Our Ref: BN/121/19/PL
Your Ref:

Town & Country Planning Act 1990 (as amended)
Town and Country Planning (Development Management Procedure) (England) Order 2015
Application for Planning Permission

Development Removal of redundant polytunnel & construction of 4 bedroom detached chalet bungalow with new vehicular entrance & relocation of Nursery parking area
Location Swallowfield Eastergate Lane Eastergate

title
Existing Location Plan

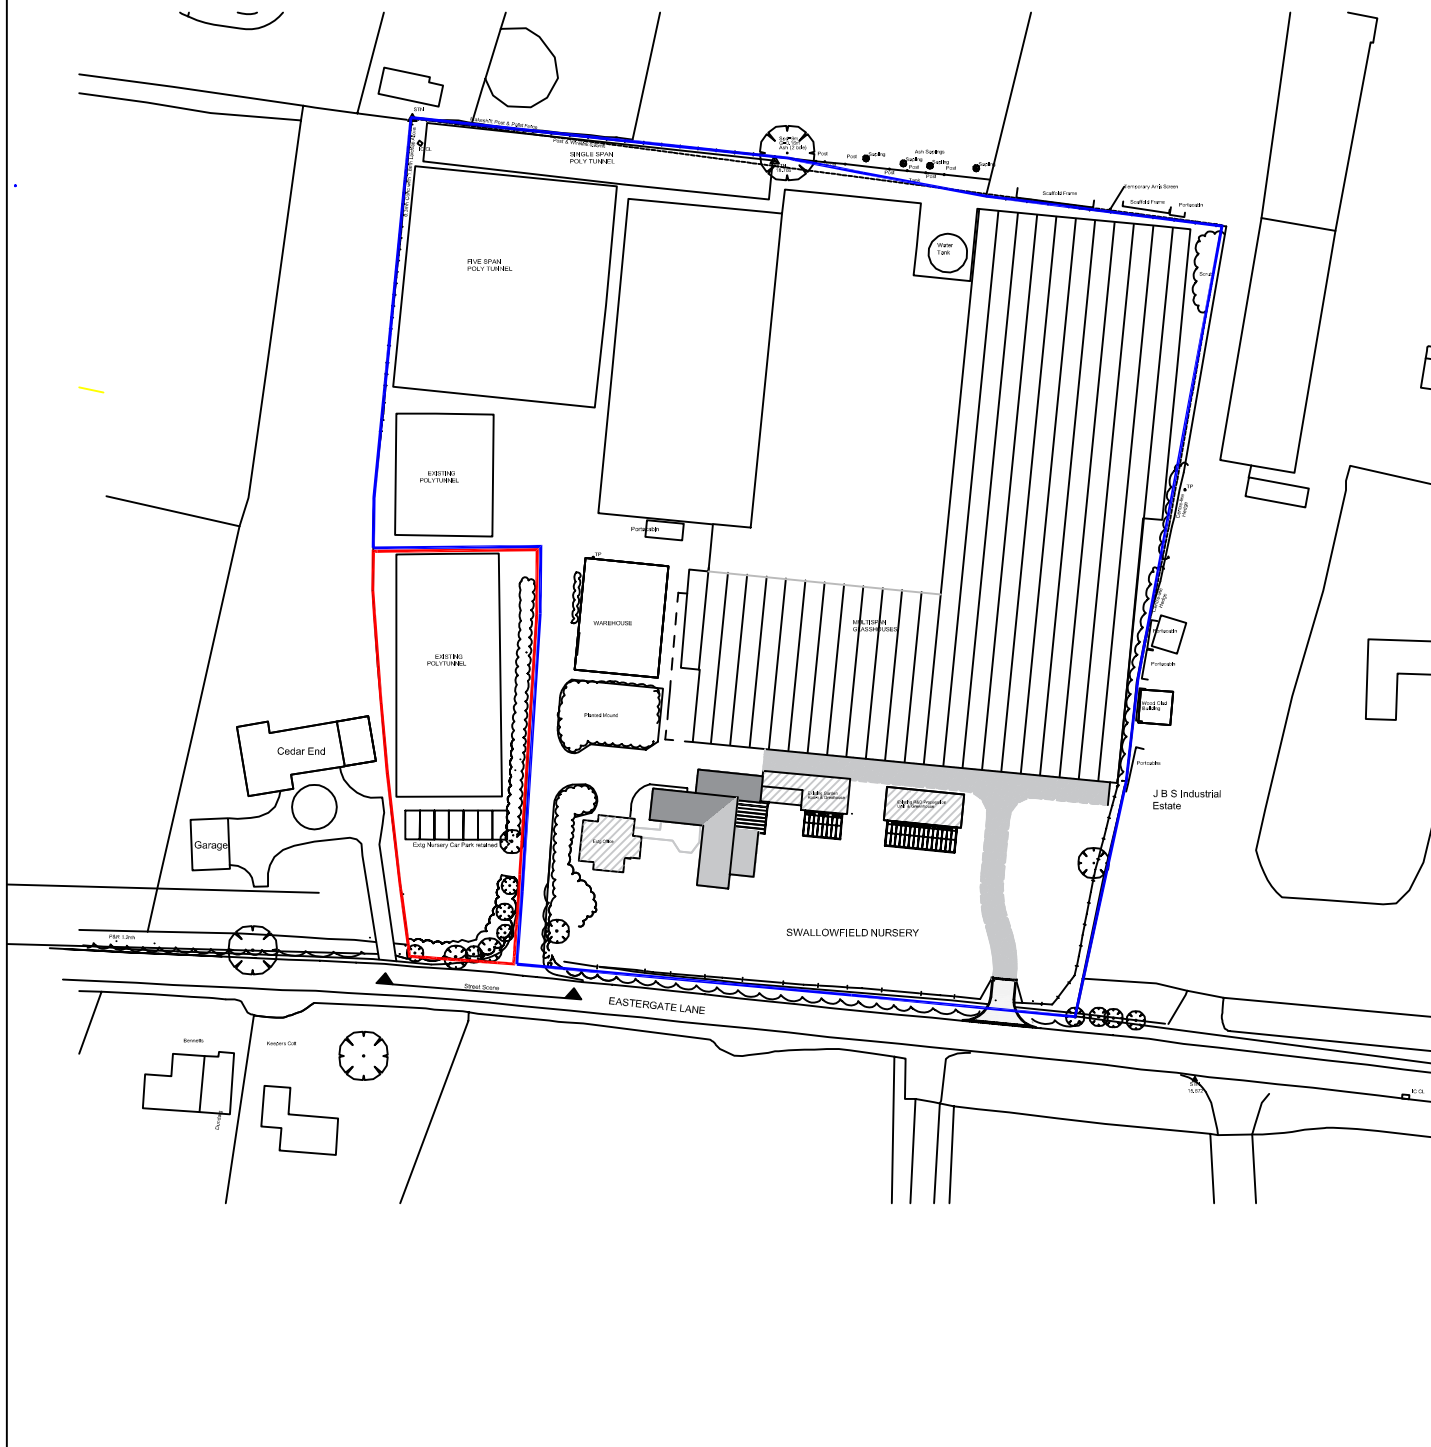
2) Plan 2a - This has been uploaded as an A2 plan not A1 and therefore is not to scale. This needs to be amended to read 'Existing Location Plan' as it currently states it is a 'Proposed Location Plan'
